Construction Drawings (PlansProfiles)_v1.pdf Markup Summary

8-29-2022

Cursory comments

OVERALL SHEET

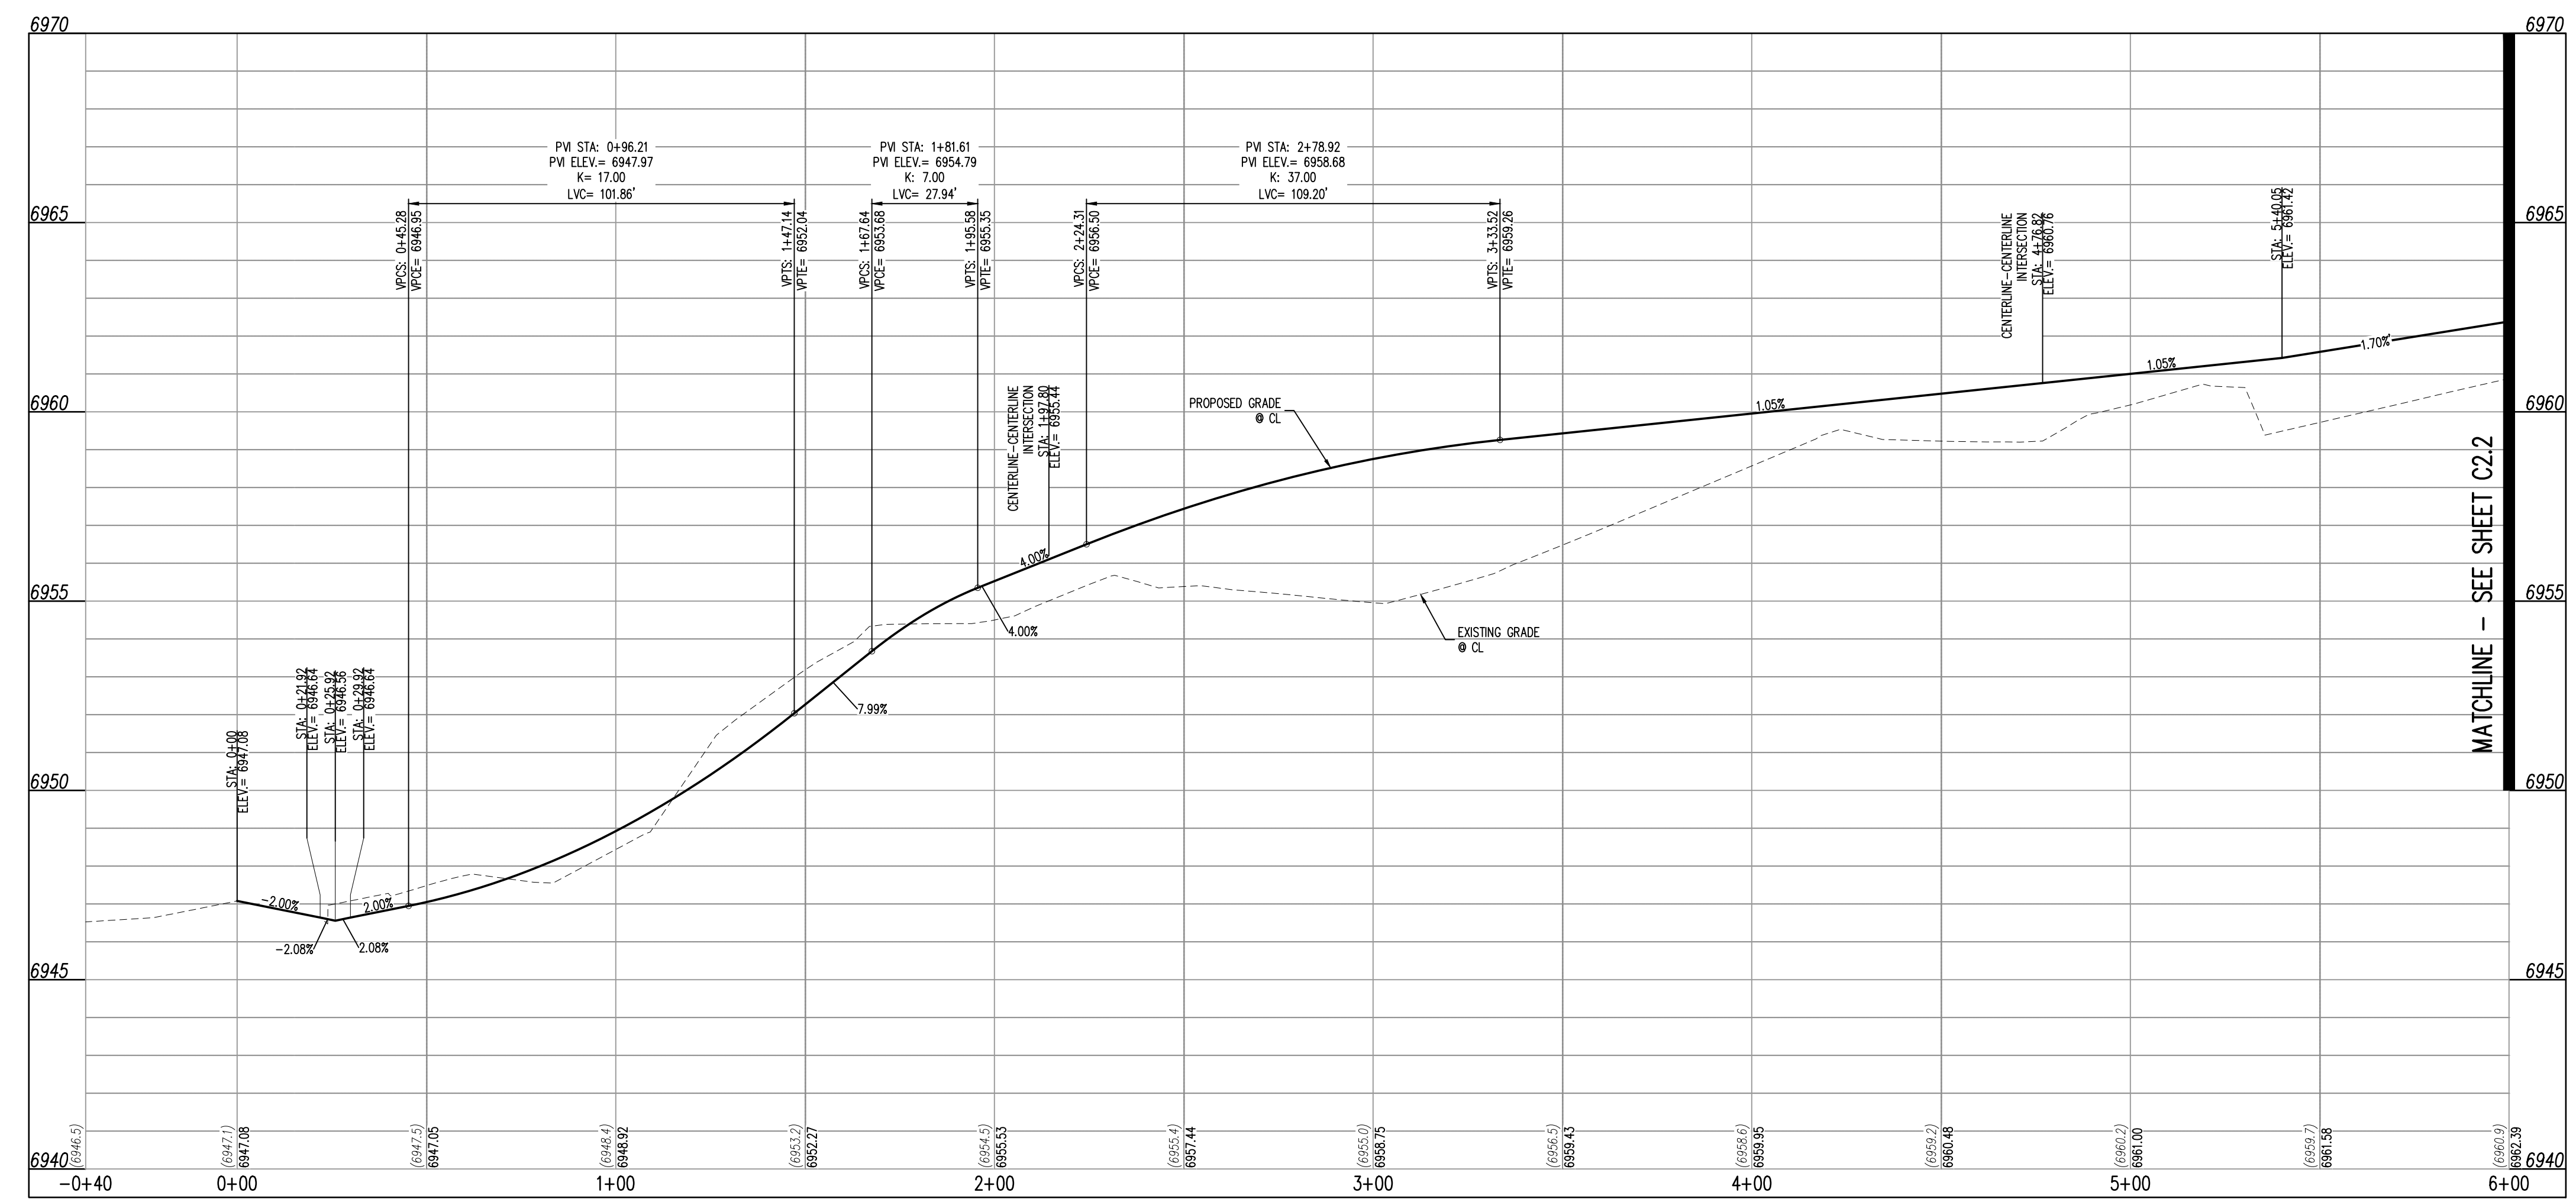
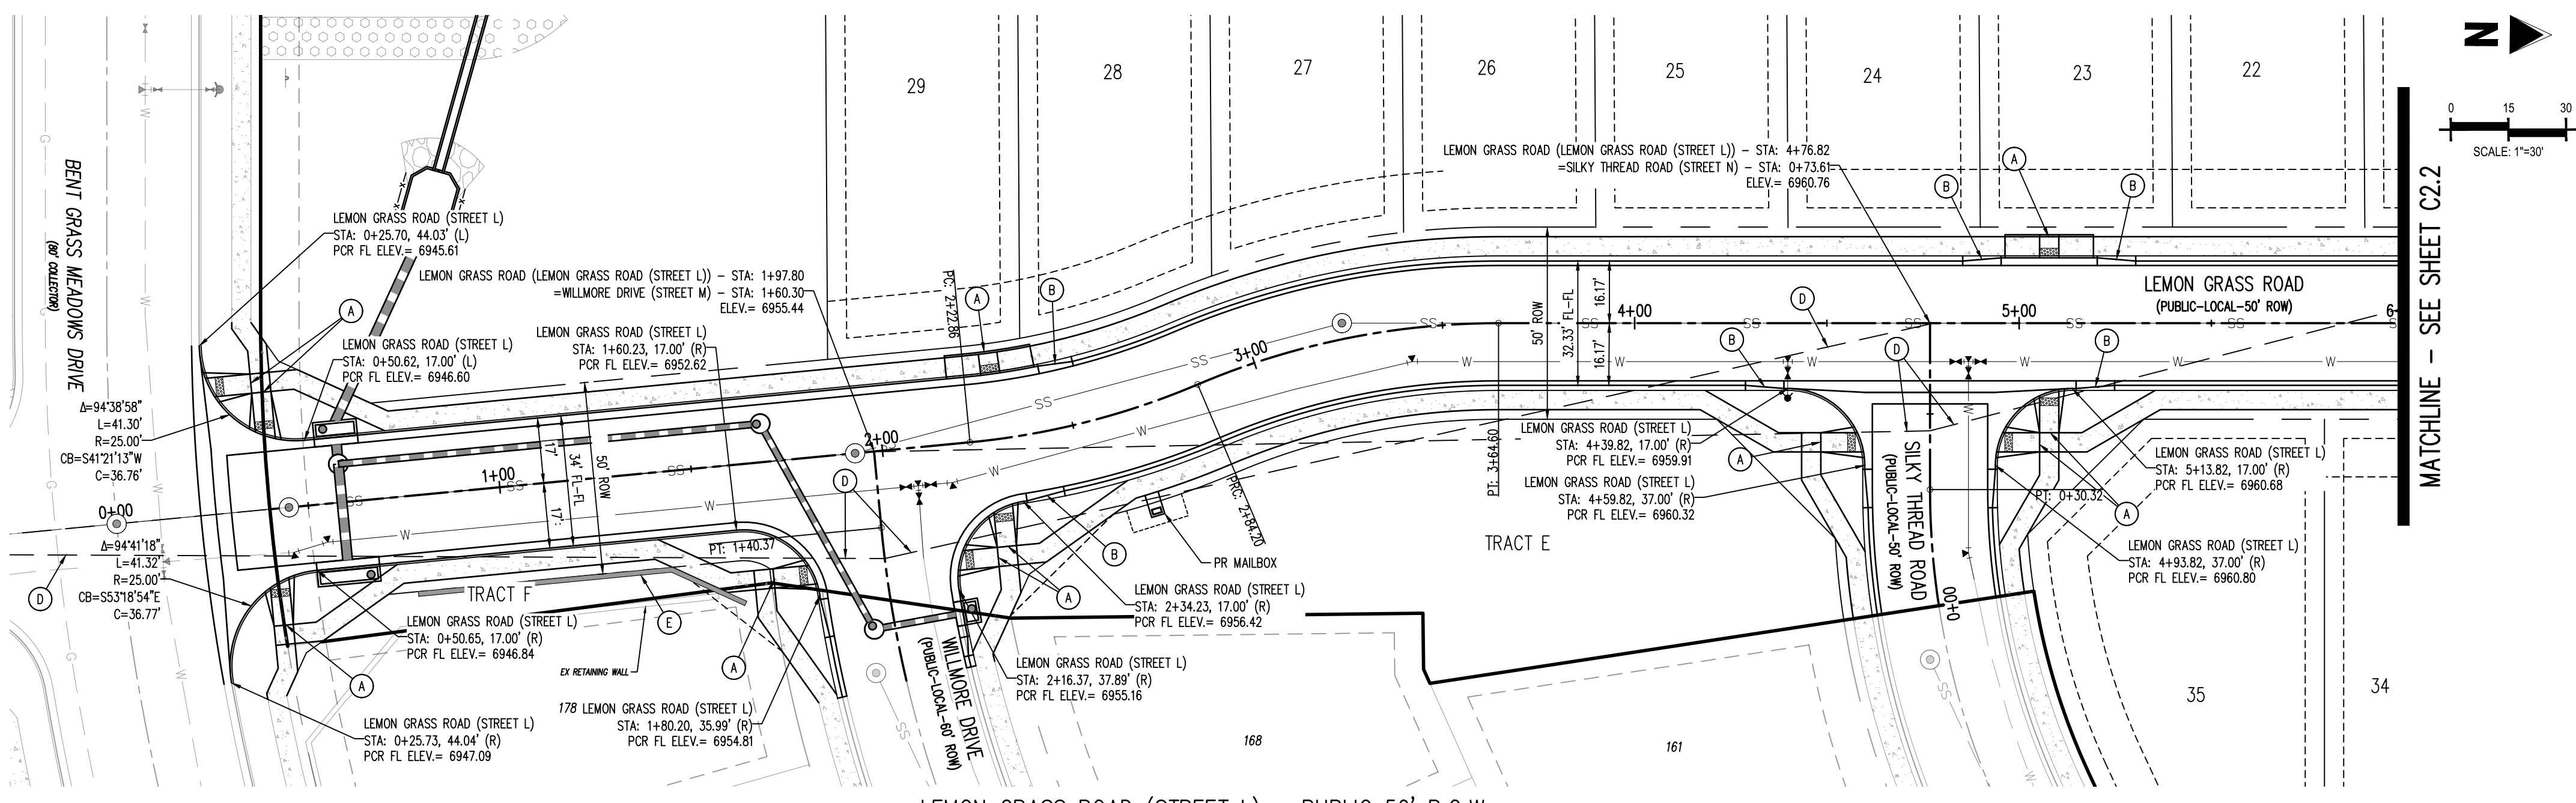
Adjust/add tracts per other comments
